CITY OF ALBUQUERQUE

PLANNING DEPARTMENT – Development & Building Services

August 29, 2013

RE: **Beehive Homes – SW Corner Four Hills Road and Wenonah NE** **L23/D022**
Four Hills Village Shopping Center, Tract 1-B2 **PE Stamp: 7/7/13**
Grading & Drainage Plan for Site Development Plan and Building Permit

COBBLE SWALE DETAIL
NTS

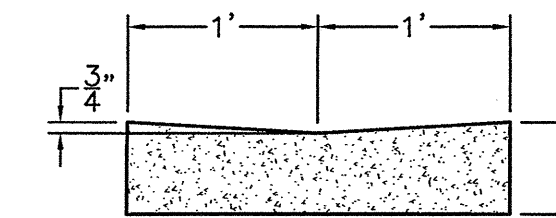
14. DETAILS, Sheet 2:
 - a. COBBLE SWALE: Are they 6" cobbles? How thick is the cobble section? Is subgrade compaction or filter fabric required?
 - b. SECTION A-A: Verify pipe slope. Show proposed direct connection of site drain to channel penetration. Clarify if the screen wall is to be built on the property line.

EMERGENCY SPILLWAY DETAIL
NTS

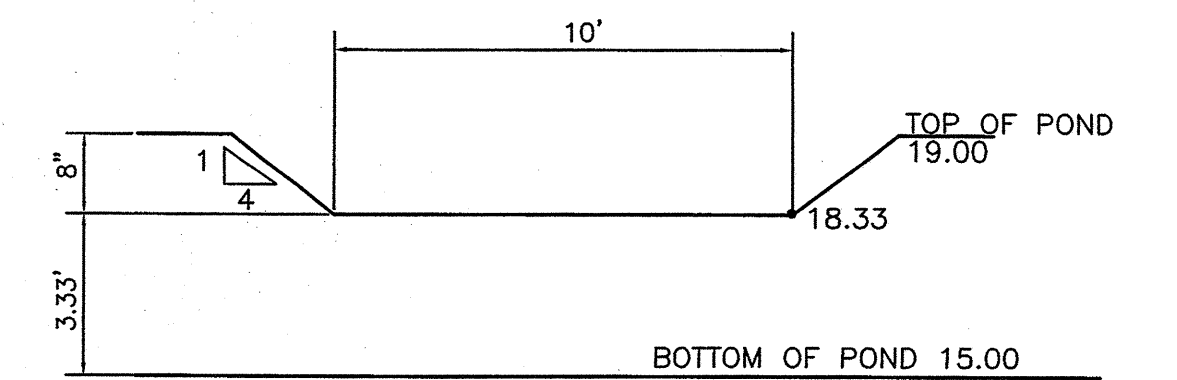
- c. SECTION B-B: Verify need for second wall, and swale lining.
 - d. EMERGENCY SPILLWAY: Revise per pond revisions discussed above.
 - e. CHANNEL PENETRATION DETAILS: Provide specific details to minimize impact on existing wall reinforcement. Discussed above...

ENGINEER'S SEAL	BEEHIVE HOMES	DRAWN BY WCUJ
DAVID SOULE NEW MEXICO REGISTERED PROFESSIONAL ENGINEER 14522	GRADING AND DRAINAGE PLAN	DATE 10-02-13
	Rio Grande Engineering 1606 CENTRAL AVENUE SUITE 201 ALBUQUERQUE, NM 87106 (505) 872-0999	21227-AYOUT-7-13-12
		SHEET # 1
		JOB # 21227

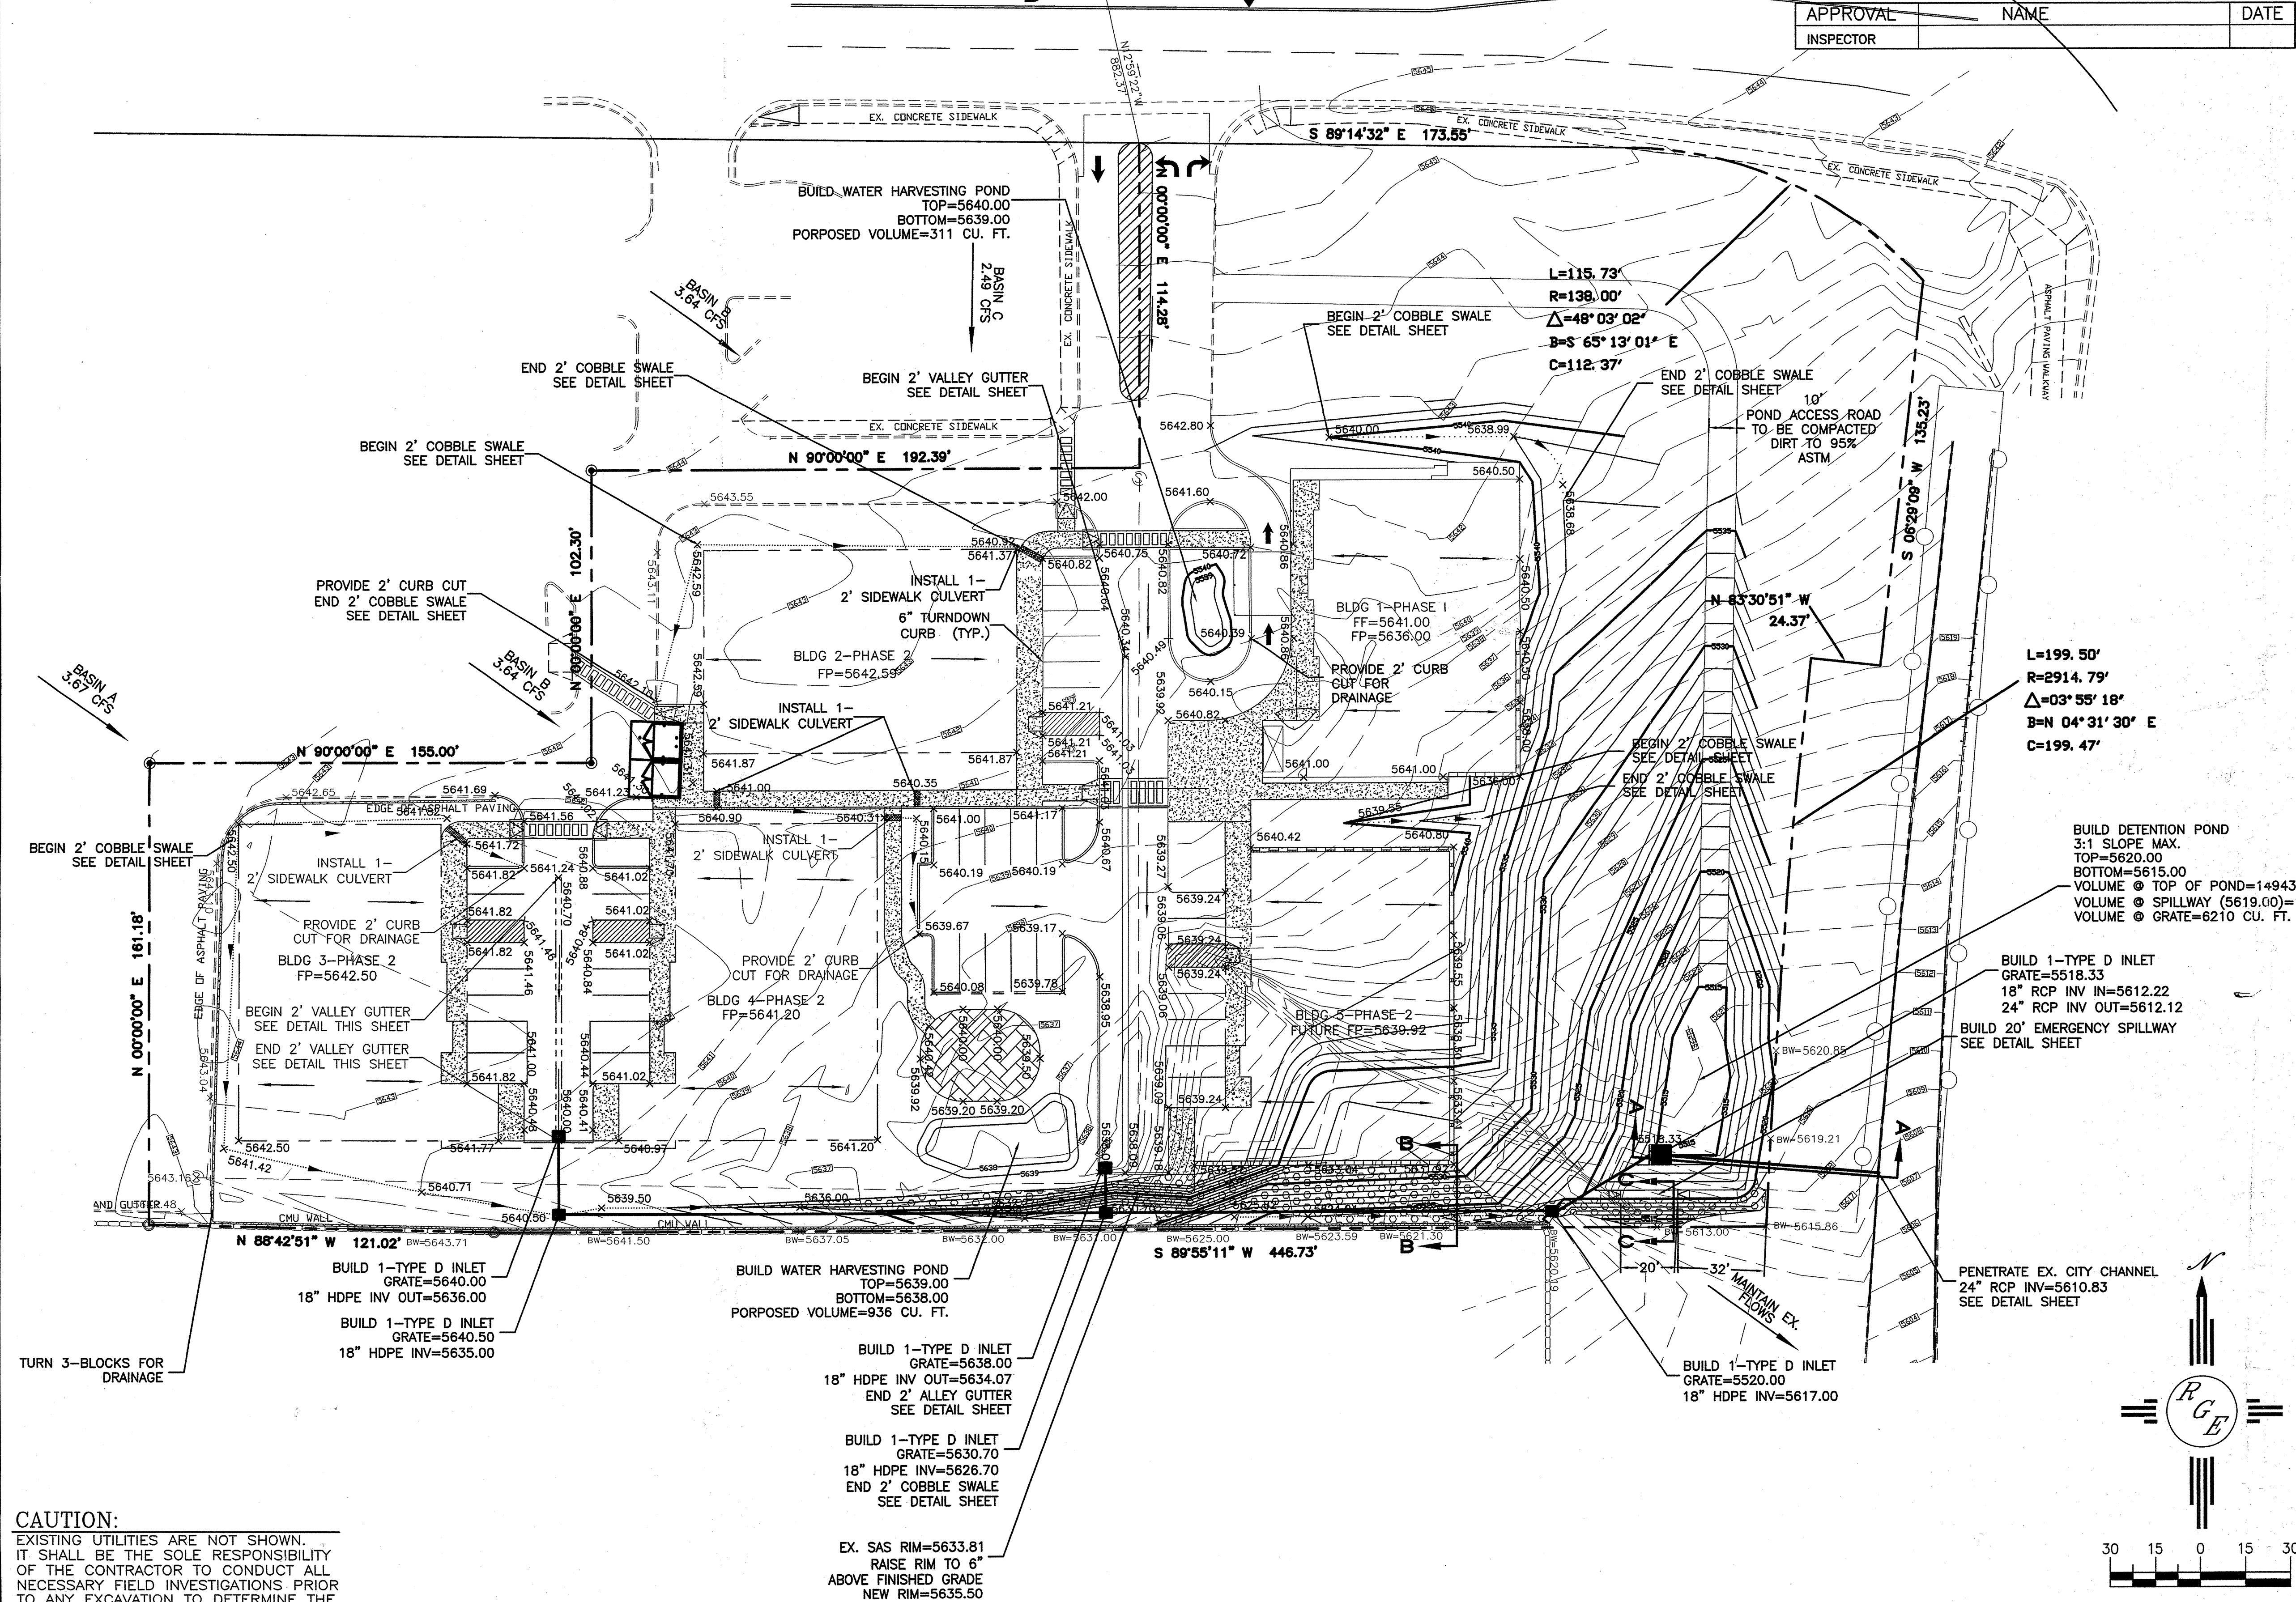
1. The abutting, Four Hills Channel is a City owned and maintained facility.
 - a. The proposed connection to the channel wall must be done under our Special Order 19 (SO-19) procedure, for Private Infrastructure within the Public R/W. These plans must include standard SO-19 notes, and specific construction details for the penetration of the vertical walled channel section.

- b. Plans must clearly require the contractor to call Storm Maintenance for inspections of the work in progress, prior to and including cutting the wall and placement of concrete. "CALL: Jason Rodriguez at 857-8074"

- c. Raise the invert of your connection about 3' above the channel bottom, to minimize the impact of this penetration on the strength of the wall.
 - d. I previously forwarded you a copy of the record drawings for a portion of the Four Hill Channel, which will give you more information on rebar size and placement, and assist in detailing the penetration of the wall.

- e. Details should call for the contractor to locate the existing rebar and adjust the penetration location to minimize the number of vertical and horizontal bars cut. To expedite approval, I suggest that you contact this office to preview your structural connection details, prior to formal submittal.

2. The Drainage Report indicates that you are retaining the first 0.44" of runoff from the site. However, the detention pond detailed has an outlet at the bottom of pond, effectively releasing all flows.

- a. Per our discussion, the site storm drain piping will be changed to connect directly to the Four Hills Channel, and by-pass the retention pond.
 - b. The pond at the SE corner of the site will be resized to accommodate expected runoff from the eastern side of the site, and some of the site water harvesting

- will be accommodated in smaller retention ponds on the upper portions of the site, filtering the first flush, and minimizing the outfall pond size?
- c. Raise the grate on the pond inlet, or substitute a stand pipe to set the pond overflow grade and retained volume.

- d. The pond spillway should be located on the south side, coincident with the existing swale.
 - e. Show how retention pond will be accessed for maintenance.

3. Clarify how site “Rough Grading” is intended to be completed, with pad elevations 5-feet below the building FF elevations? This is critical as building completions are expected to be done in phases.

4. Label the building numbers and phases anticipated by the developer.
 5. What is the purpose of the CMU wall shown along the south side of the site? It appears to create a “no-mans-land” between it and the existing garden walls, with no means of access for maintenance. Will the south swale be plated, similar to the 2:1 slope?

6. Drafting issues that need to be corrected:
 - a. Legend symbologies chosen tend to obscure some of the critical details, or are not clearly differentiable. (e.g.- the Retaining Wall and Stem walls are too similar; limits of retaining wall at SE corner; the rock plating obscures contours; etc.)

- b. The proposed contour labels are not legible
 - c. Clarify limits of paving, and add sidewalks/conc.(?) symbol to the Legend.
 - d. What are the limits of the Cobble Swale(s)? Same line type has been used for cobble and non-cobble swales.

- e.
 7. The drainage plan needs to include flow arrows where off-site flows enter the site, and indicate the design Q's. Also, show how/where on-site flows get into the Water Harvesting Ponds, and indicate estimated volumes retained.

8. Show where roof flows leave the structures and enter the site drainage paths.
 9. Clarify the inlet details at the southern ends of the paved areas, and show how flows will be captured by the inlet, and not allowed to overflow to the landscaped area and steep southern slopes/swale.

10. The flow course between the two central buildings shows flow southerly, crossing under the sidewalk but, the grades slope north. Also, just east of that sidewalk culvert location, flows appear to cross the sidewalk without a pipe or culvert.

11. At the NW corner of the western building pad, the swale appears to cut under the building corner.
12. Clarify grades around parking areas, typical; sidewalk grades vs. pavement grades. Provide flow arrows and Proposed Contours to clarify flow patterns.

13. Records indicate a public sanitary sewer line passing through the site, with a manhole at the south end of your easterly access drive. Show the manhole on this plan, and clarify grades in the area to ensure that site runoff does not drain into the manhole cover openings.
